ENG-SF18025-R3-Plat.pdf Markup Summary

ENG-SF18025-R3-FDR_Markup Summary

ENG-SF18025-R3-GEC_Markup Summary

ENG-SF18025-R3-CD_Markup Summary

DRAWING: 18026FP.DWG PAGE 4 OF 4

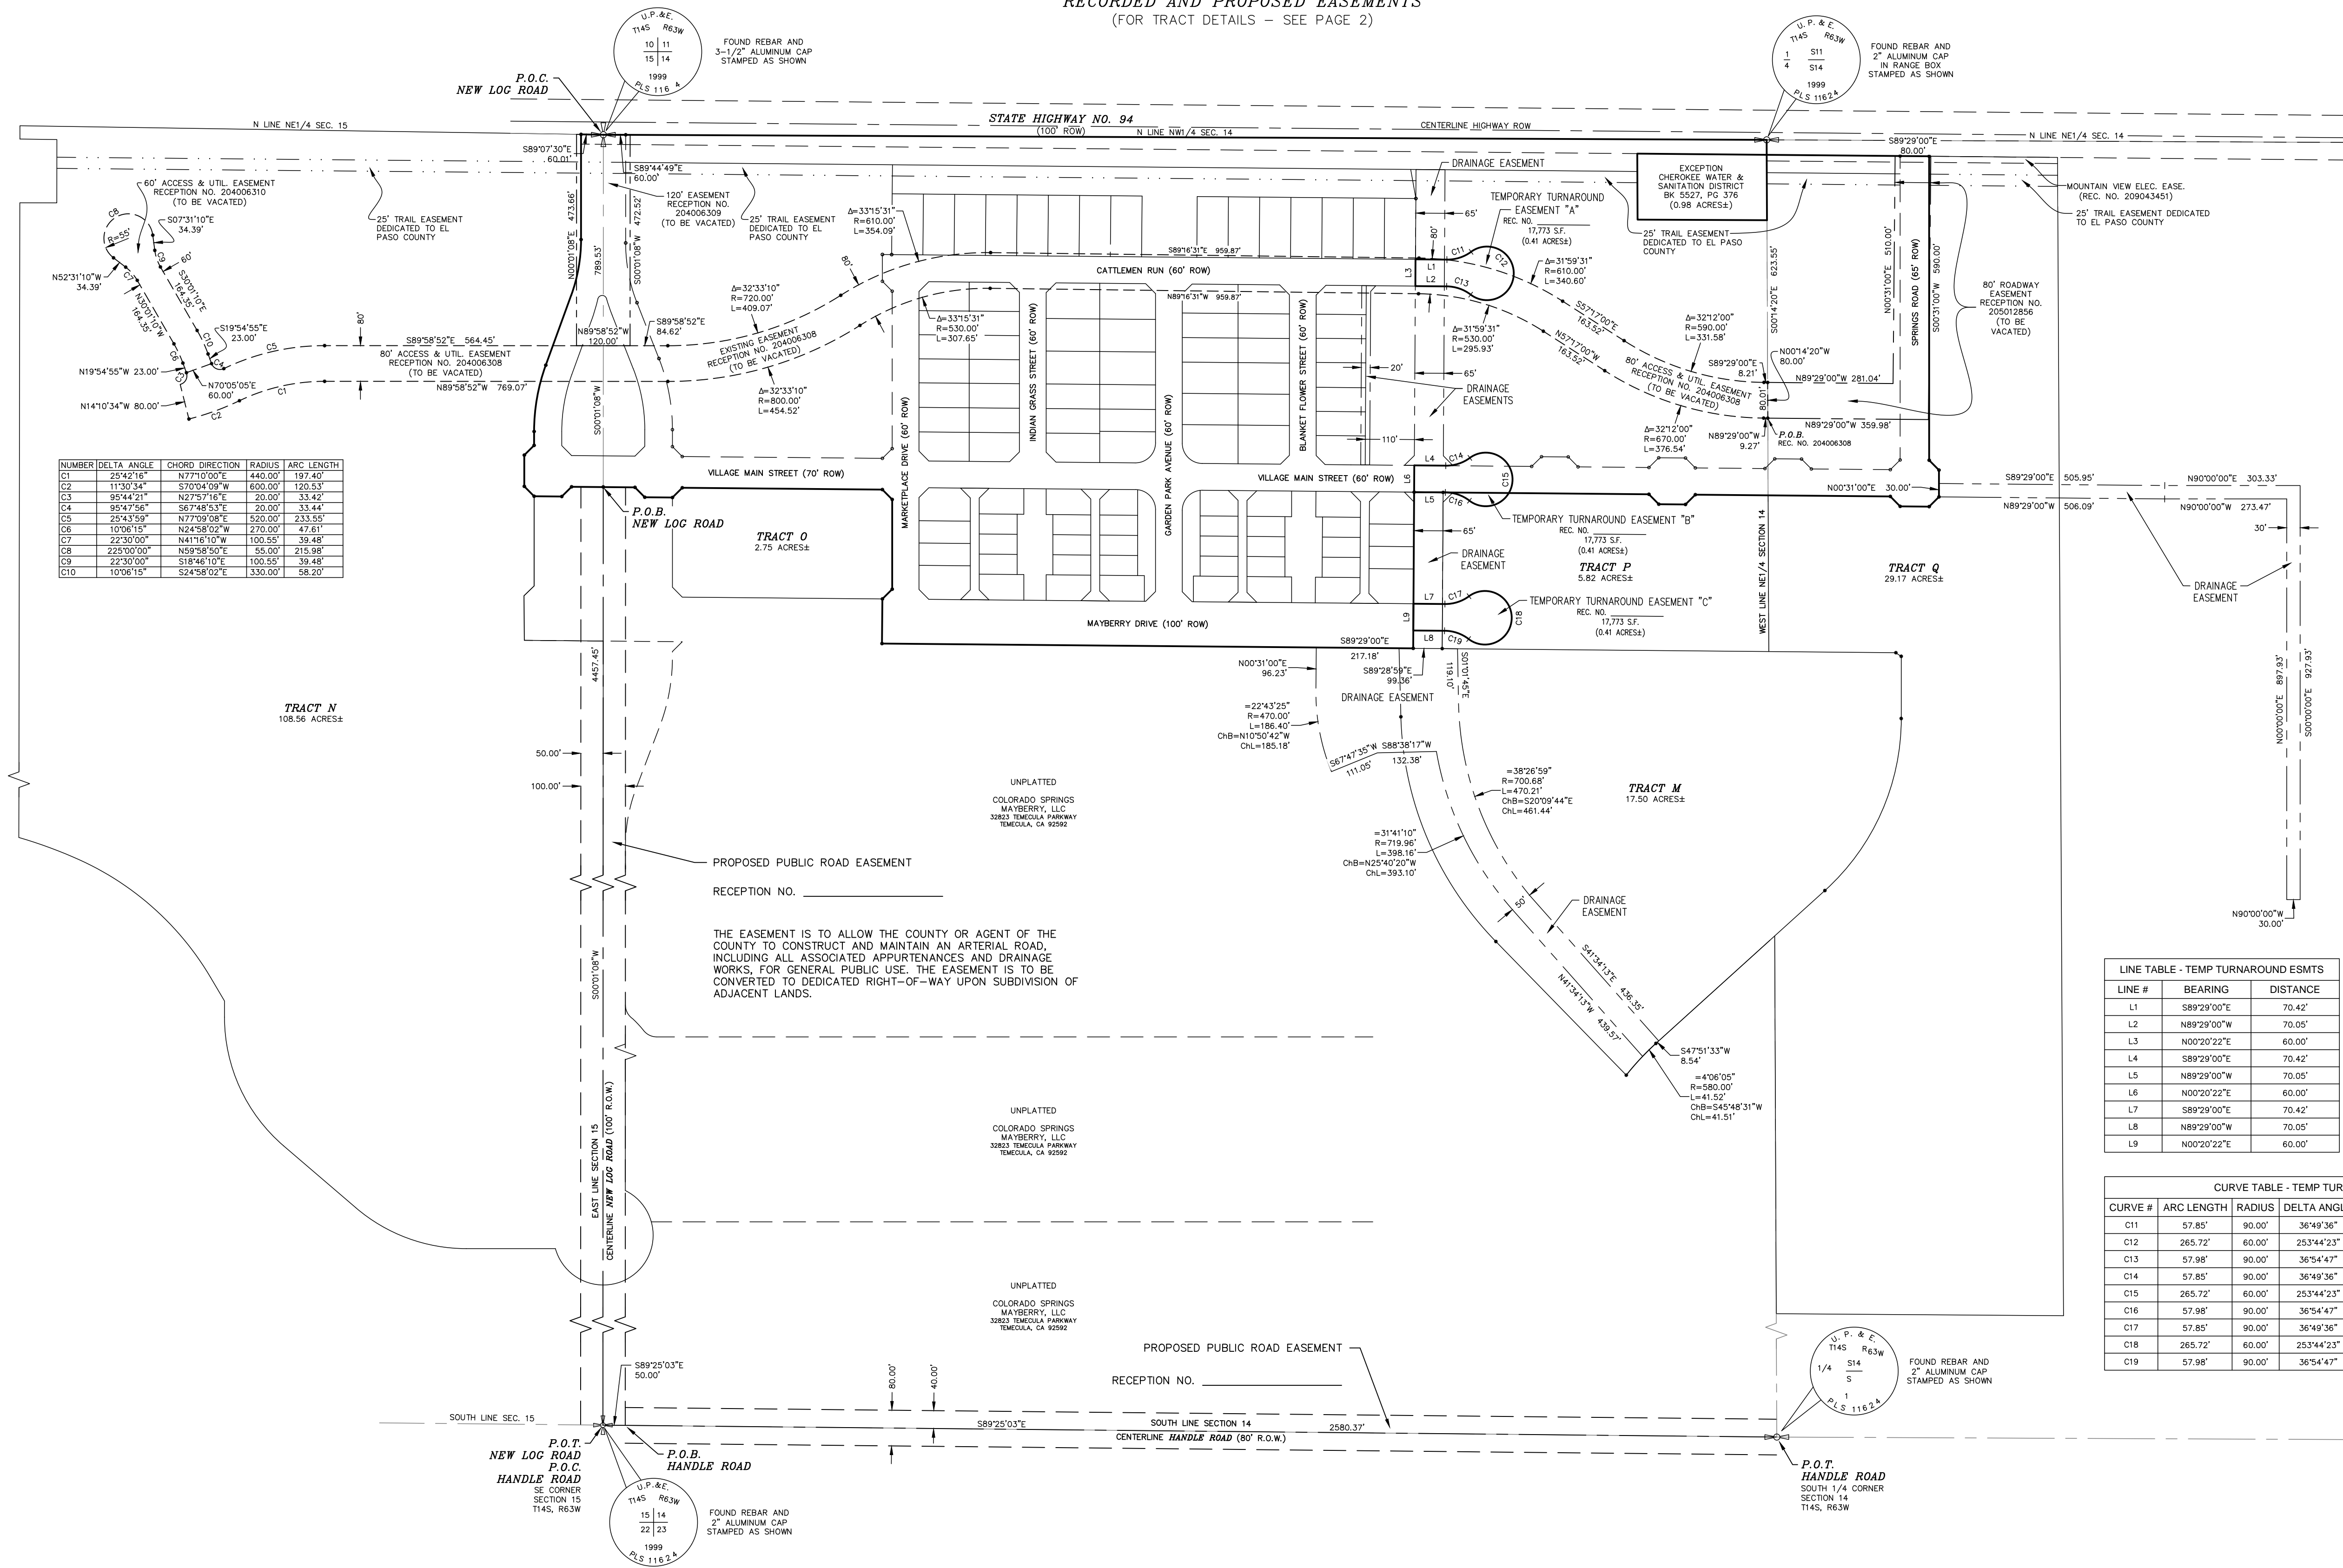
Provide blank for reception number(s) for
cul-de-sac NEPE(s).
